12/02/2021

**Alterations and Additions to President Private Hospital (SSD-10320)  
Response to Submissions**

Project number	MacHealth-06	A 028	
Date	13/12/2021	Scale @ A1	Plot stamp:
Drawn by	Author	1 : 100	25/02/2022 2:22:51 PM
Checked by	Checker	Version:	60

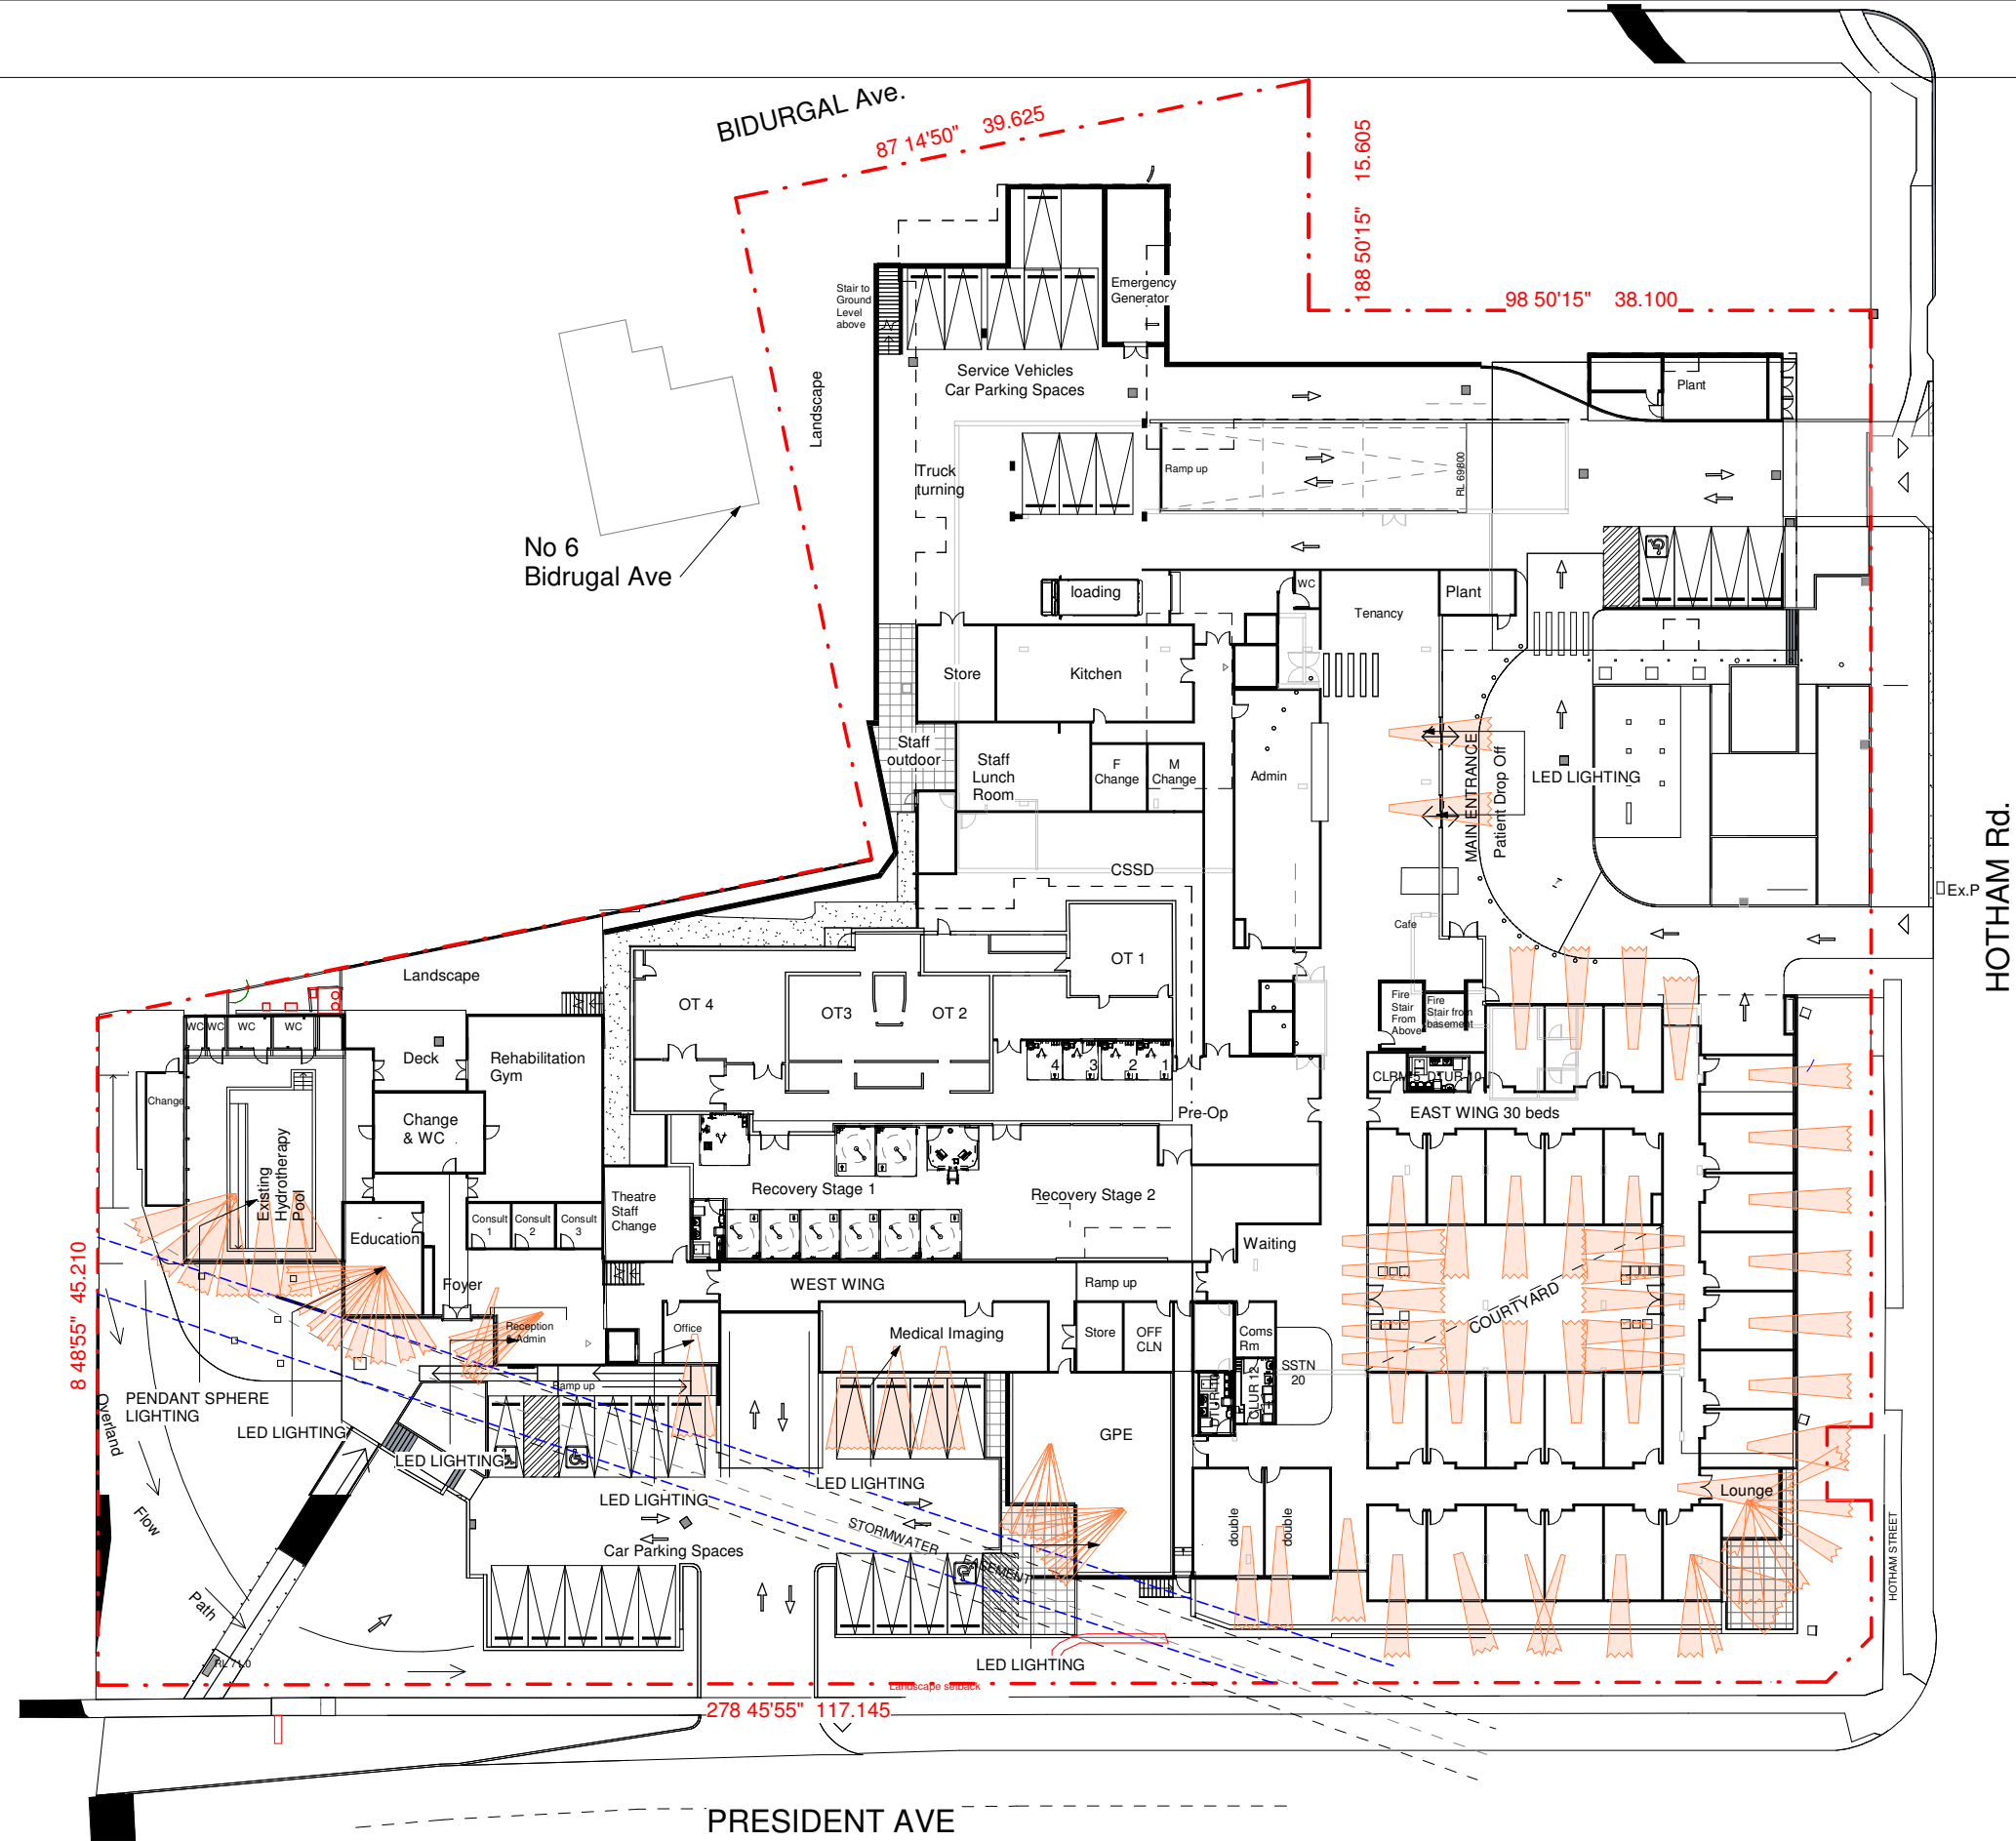
- to address the consistency of the development with the R2 zone objectives.
- appropriate flood/drainage measures are to be provided at the carpark entrances, particularly the west carpark, where the site is flood affected. Additionally, in accordance with Council's comments the flood model, flood report and architectural drawings are all to

be updated and resubmitted with the necessary investigative details that have been requested by Council.

Proposed Ground Floor Plan- Expected Internal Light Spill		
Project number	MacHealth-06	A 031
Date	13/12/2021	
Drawn by	MO	Scale @ A1
Checked by	SP	1 : 250
		Plot stamp: 25/02/2022 2:22:56 PM
		Version: 60

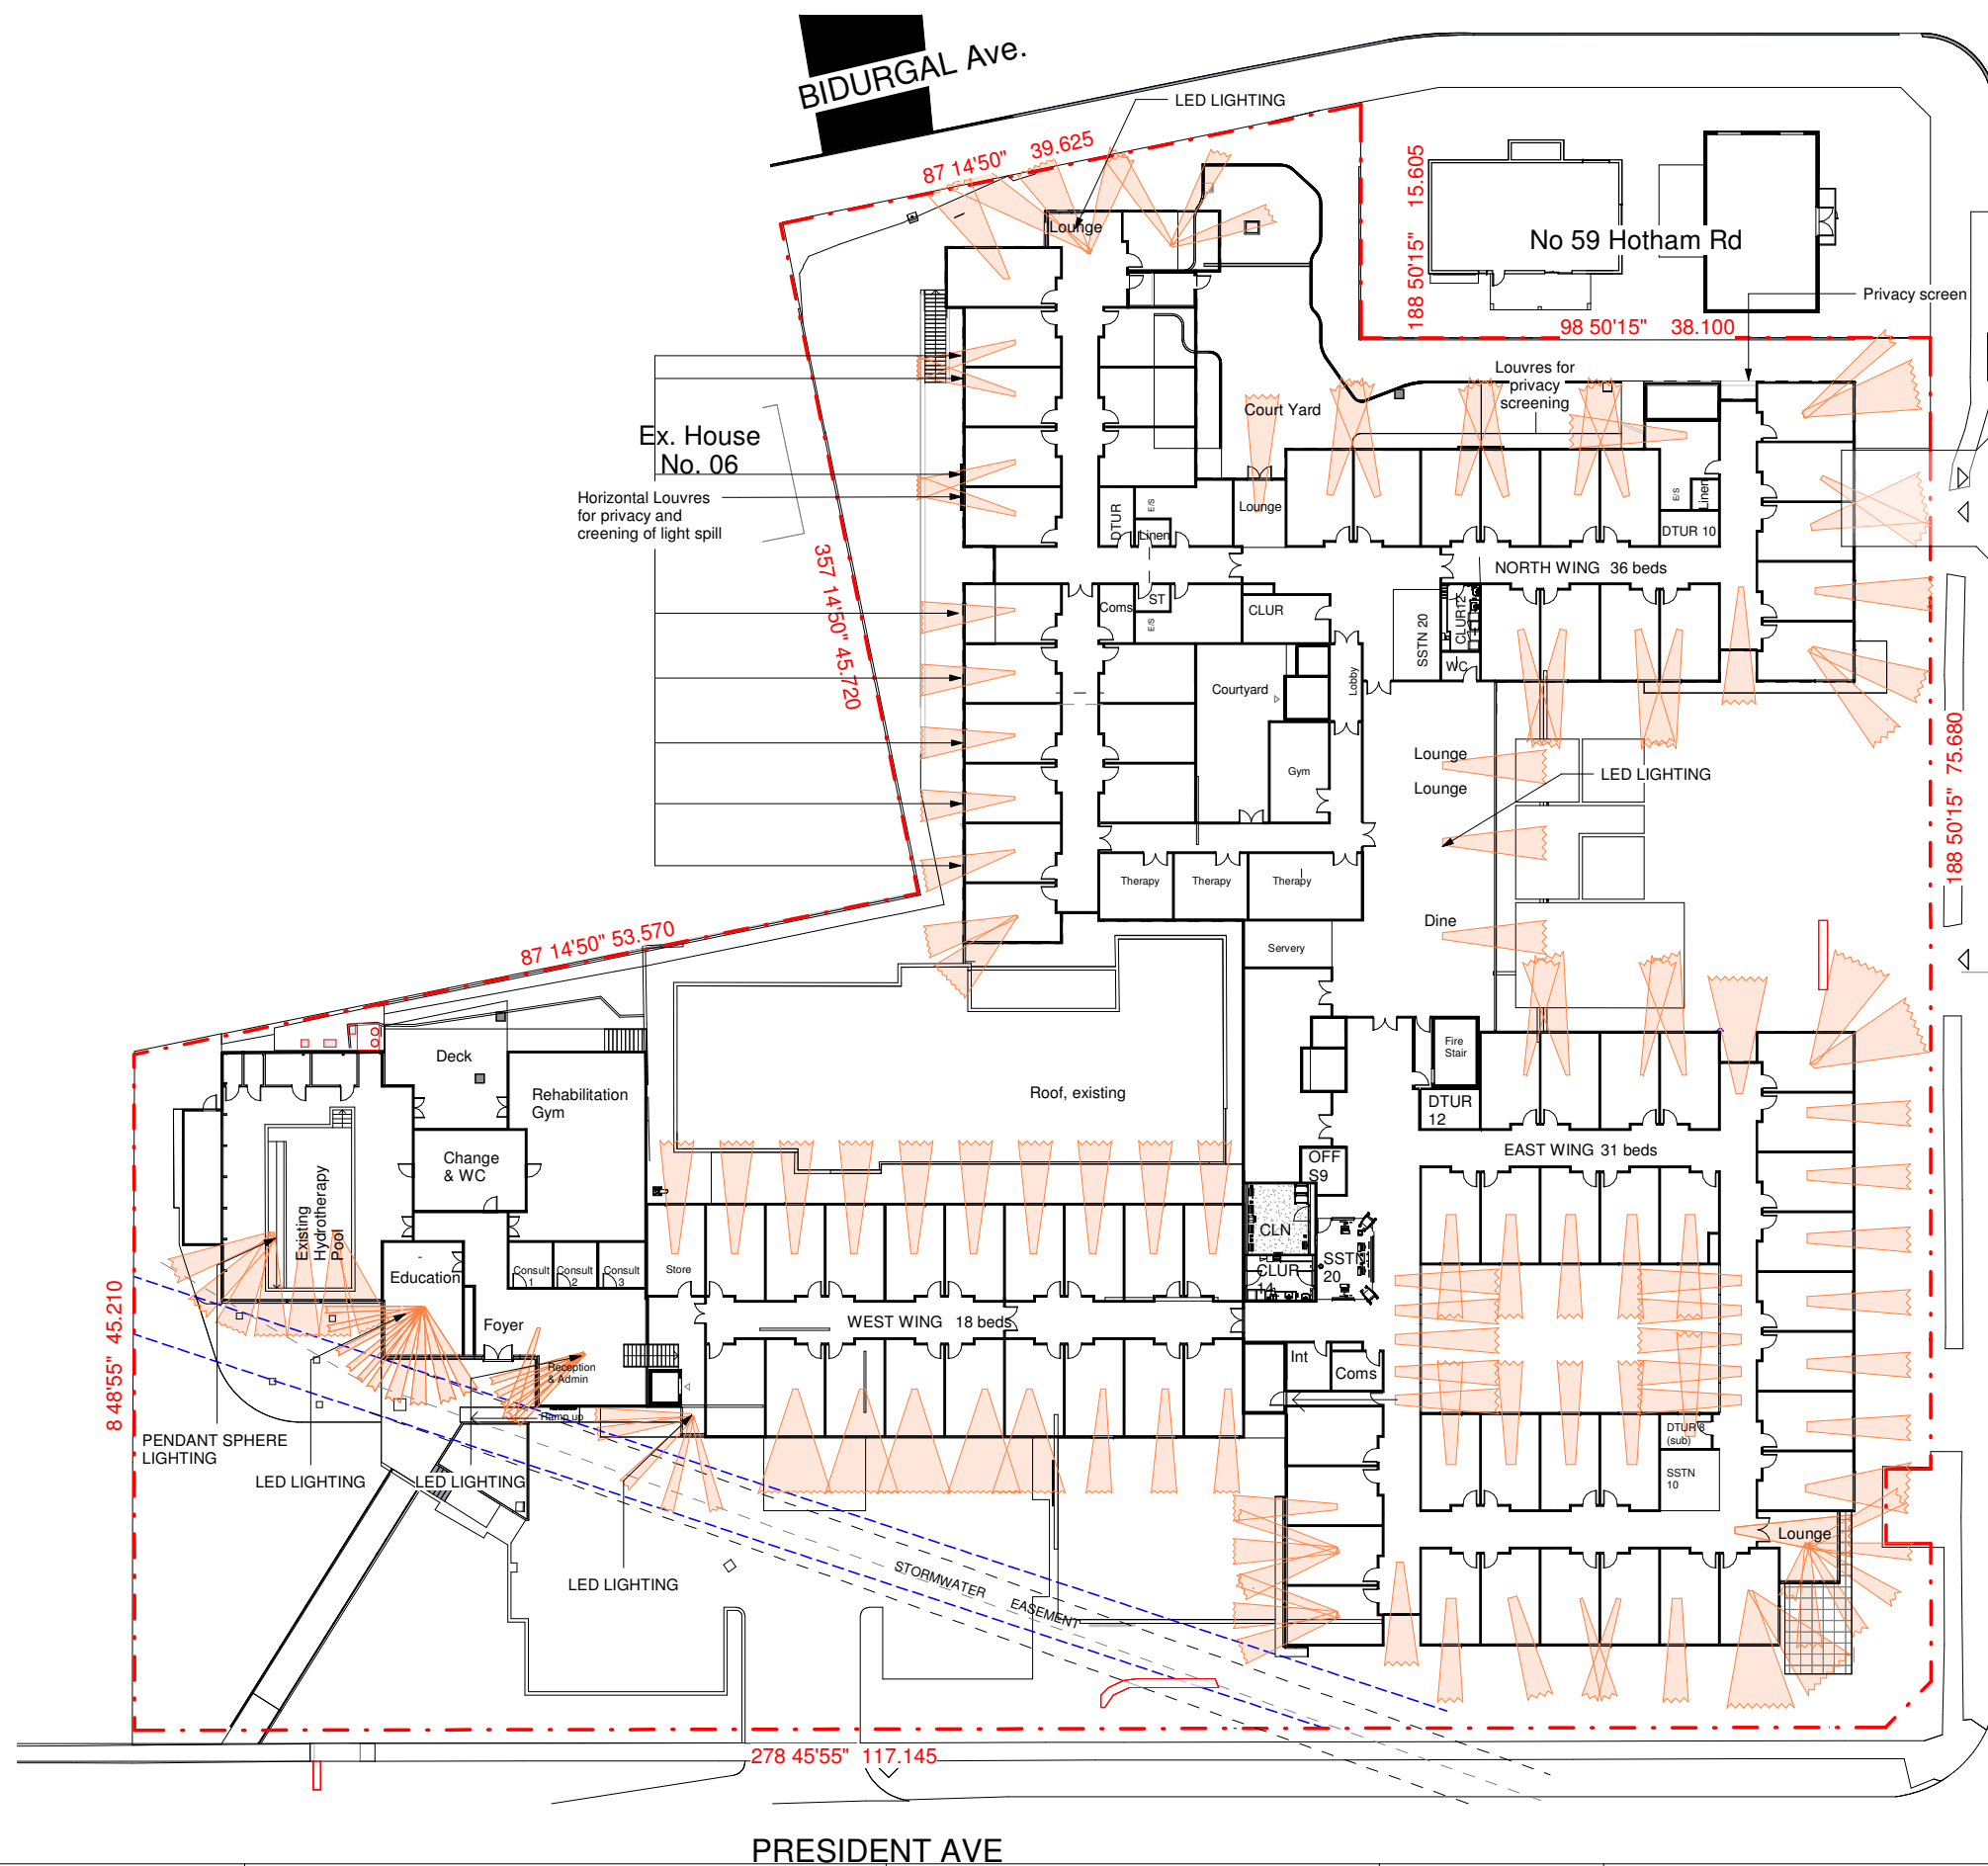
- expected light spill impacts on residential properties adjoining the northern boundary of the hospital site are to be further addressed. The use of trees to block the light spill isn't considered a satisfactory resolution, especially when the hospital is proposed to operate 24 hours a day, seven days a week. It is therefore requested that a more acceptable resolution of light spill is provided.

A 402

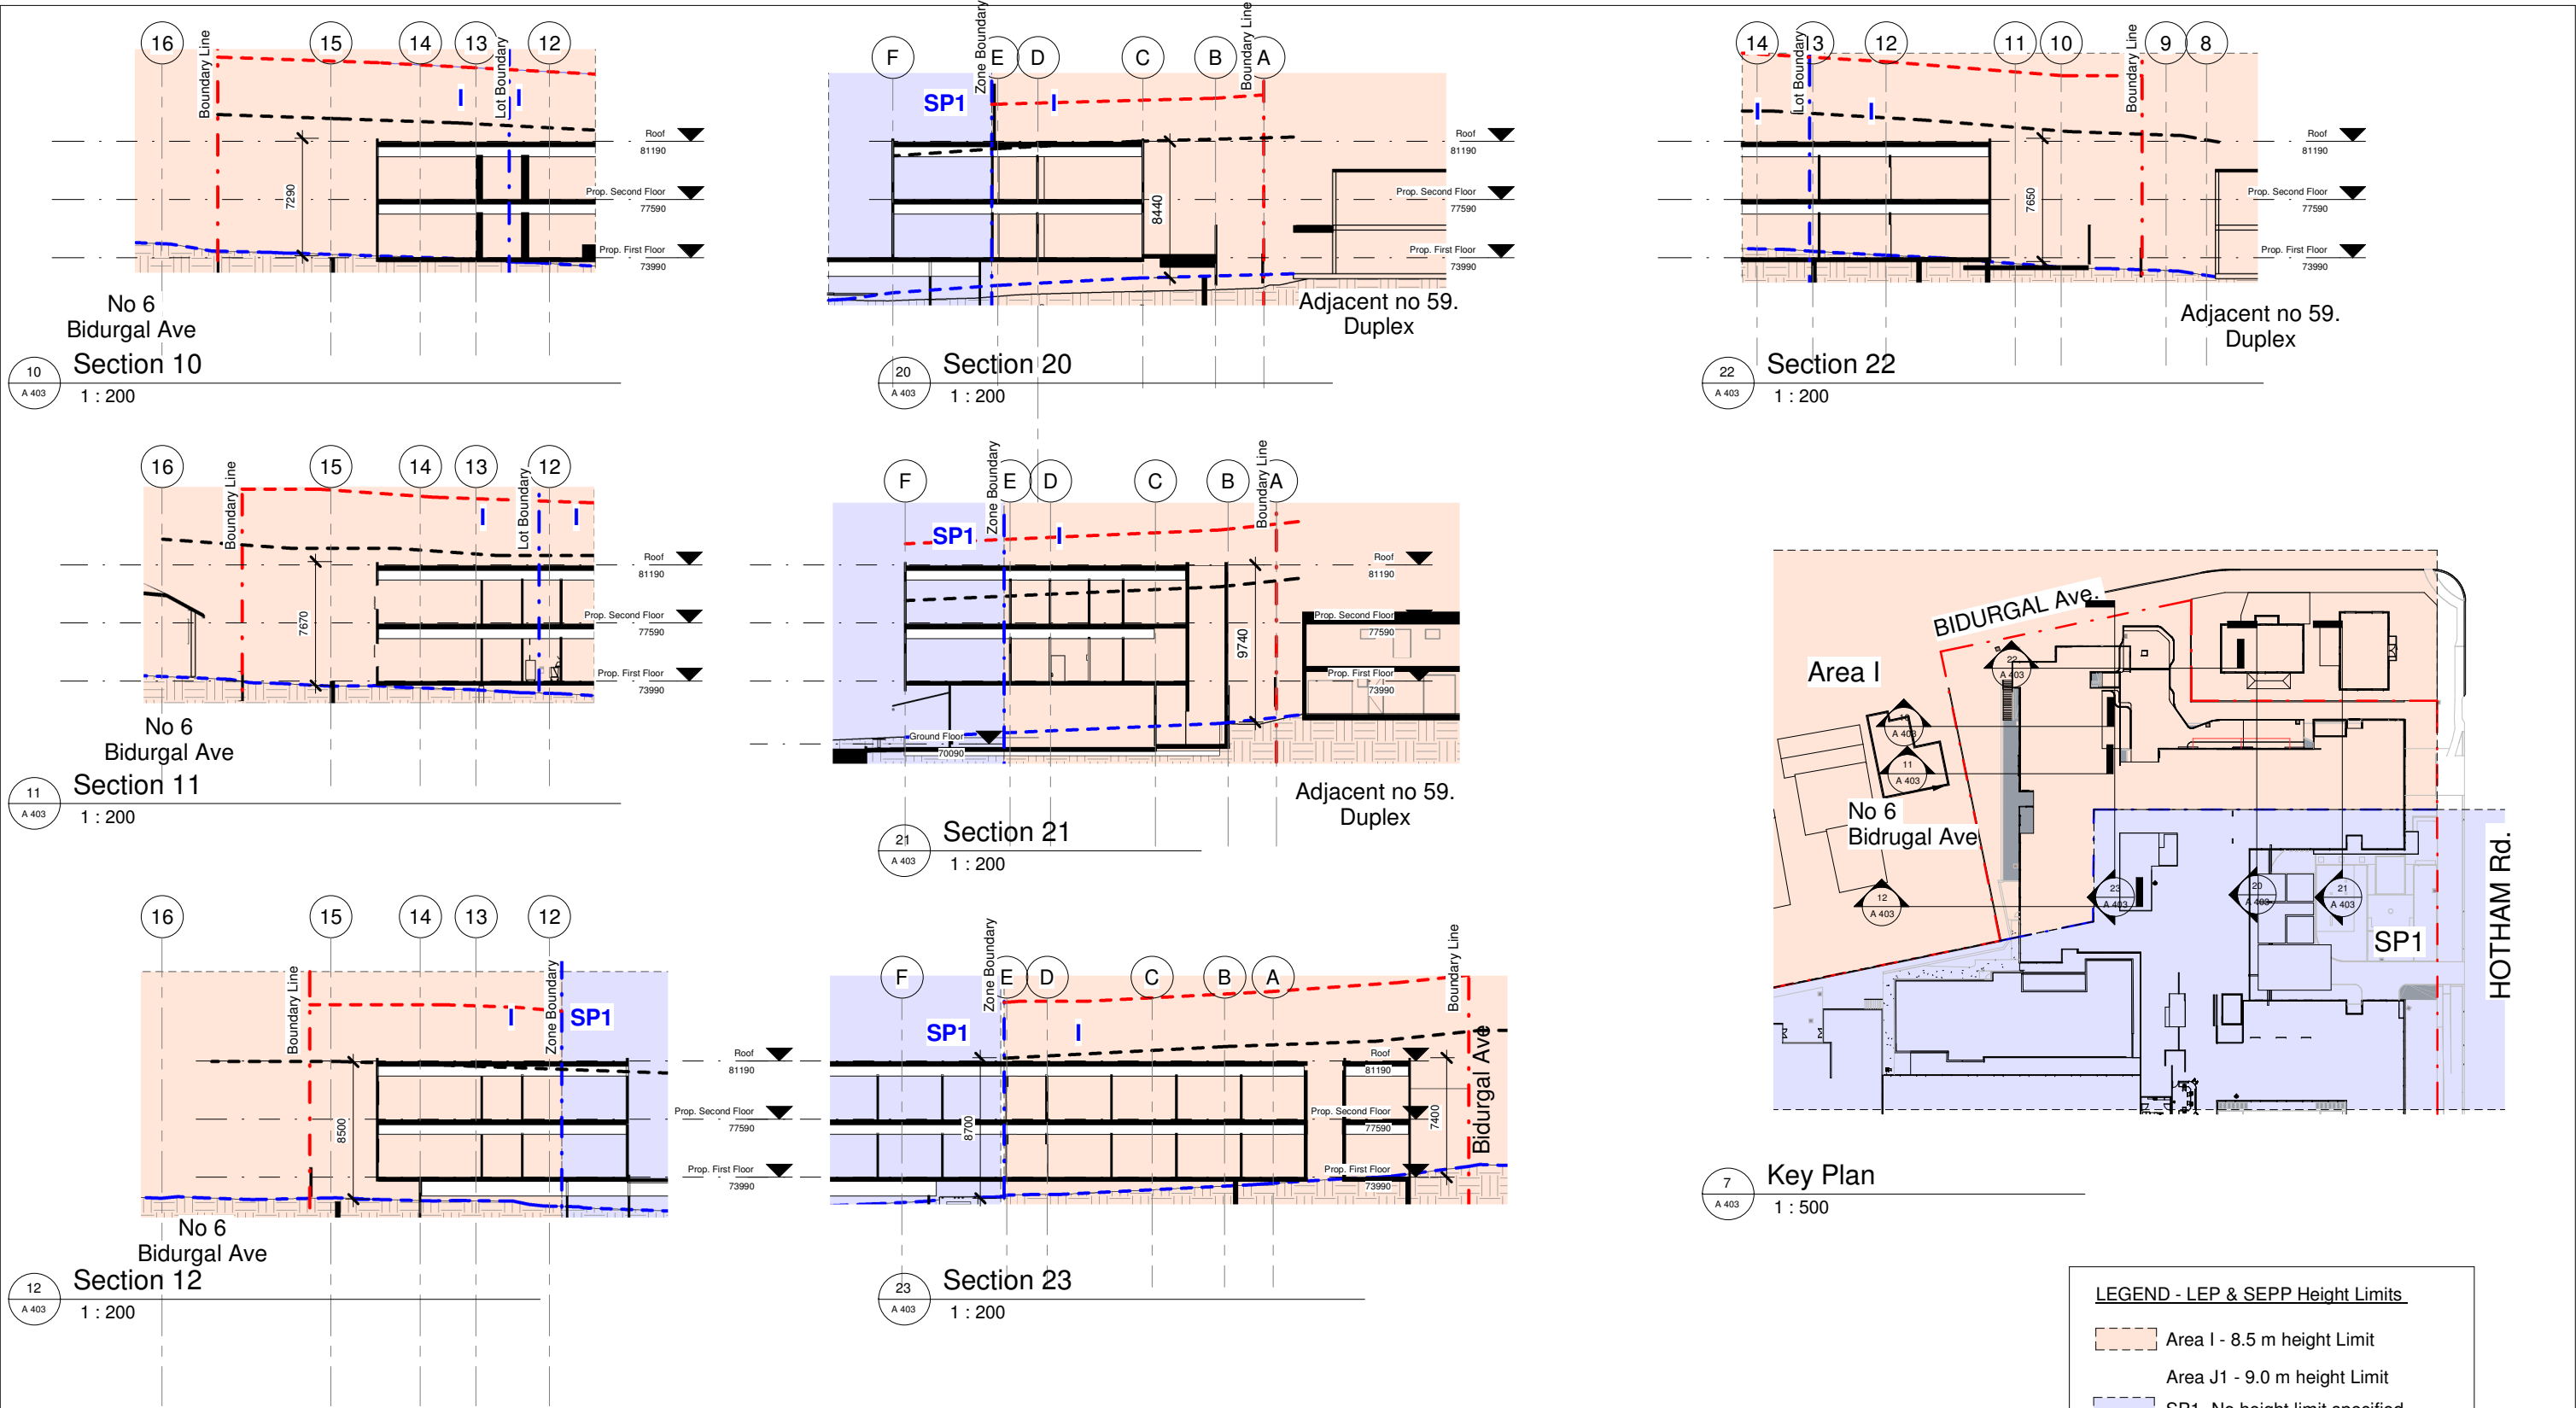
- the Section 04 architectural diagram within the architectural plans package appears to demonstrate a height exceeding 15m, whereas the EIS states that the highest point of the proposal within the SP1 zone will be below 15m. In addition, for the portions of the development which fall into the R2 zone, the height restriction is 5.5m and therefore the proposed building height of 7.5m exceeds this requirement. It is therefore requested that a clause 4.6 variation be prepared justifying the LEP non-compliances.
